PORTLAND MAINE

June 6, 2012

RE: 144 Holm Avenue – 270 A006 - R3 – deck & shed – permit application # 2012-05-4085

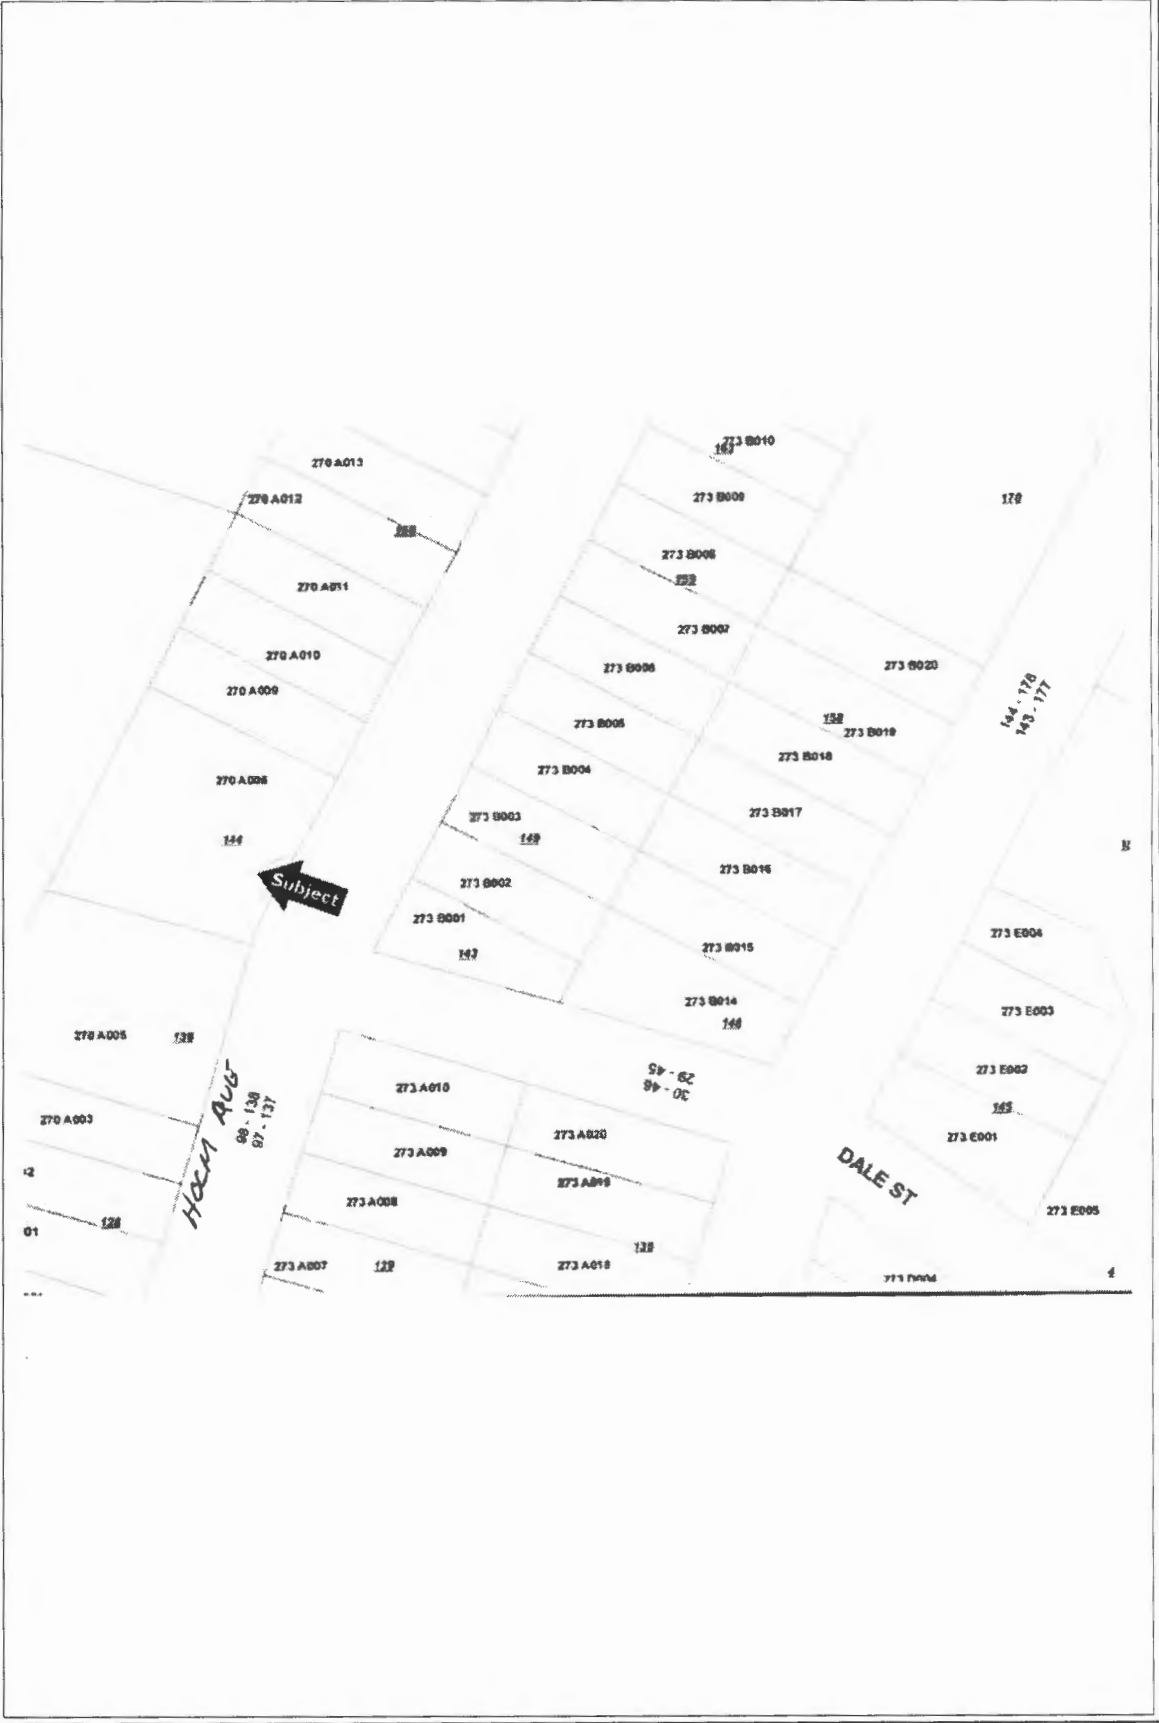
In reviewing your building permit to add a one story 7' x 15' addition to your house at 144 Holm Avenue, it came to our attention that the deck on the rear of the house and the shed on the rear of the garage do not meet the rear setback. Your house is located in a R3 Zone. The rear setback in the R3 Zone is twenty-five feet (section 14 – 90(d)(2)). The revised plot plan that you provided with the building permit, shows the shed is 17' from the rear property line and the deck is 15'8" from the rear property line and therefore in violation of the ordinance. Our files indicate that permits were never issued for the shed or the deck. Since they were built without permits, you have no rights to them.

You need to bring your property into compliance. We will work with you through the permitting process to modify and legalize the part of the deck that is not located within the twenty-five foot rear setback, but the part of the deck that is in violation of the setback and the shed must be removed within thirty days.
